**Housing Strategy and Development Team  
Housing Services  
Planning Application Comments**

**Planning Application Number:** 21/03639/F

**Site Name:** Os Parcels 6741 And 5426 West Cricket Field North, Wykham Lane, Bodicote

**Date of Comments:** 06/01/2022

REV	DESCRIPTION	DATE	AUTH	CHK'D
REV A:	NDSS housetype re-elevated to suit neighbourhood character.	03.02.22	RH	IR
REV B:	Bed Spaces Updated	23.02.22	JD	IR
REV C:	NDSS 5 Person house	07.03.22	IR

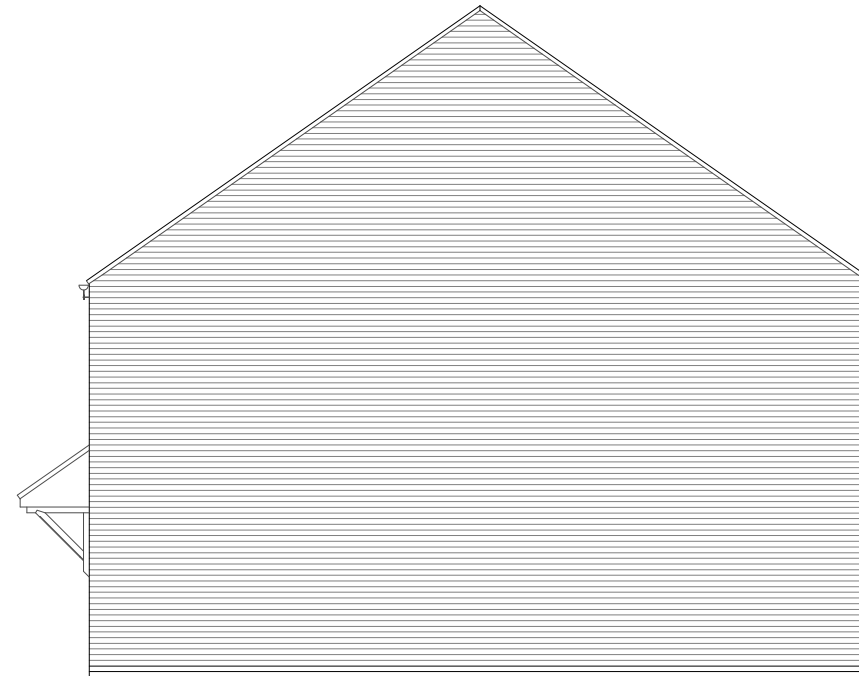
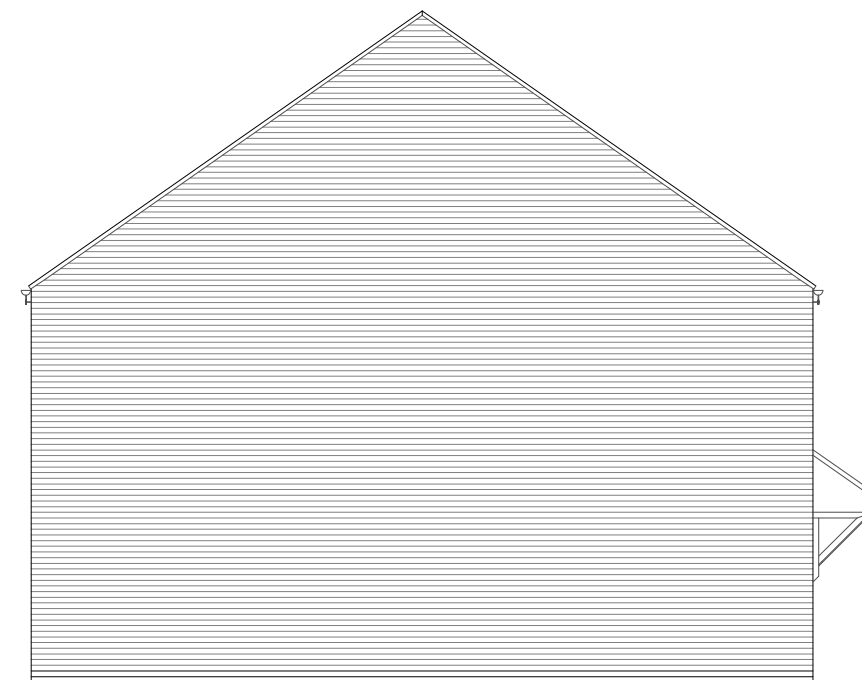
1. The plans for property type SH52 (plots 17, 18 & 19) state that they are 3-bed 5-person houses with a GIA of 86m<sup>2</sup>. The minimum required by Nationally Described Space Standards (NDSS) for this property size is 93m<sup>2</sup> with internal storage of 2.5m<sup>2</sup>. We require that this standard is met as a minimum. We will not accept replacement with a smaller size eg 3 bed 4-person as the need is for larger sized dwellings, particularly since the pandemic and the need for increased space at home. We therefore require the provision of 3-bed 5-person dwellings with a minimum GIA of 93m<sup>2</sup> or if possible, 3-bed 6-person dwellings with a minimum GIA of 102m<sup>2</sup> or a mix of both.
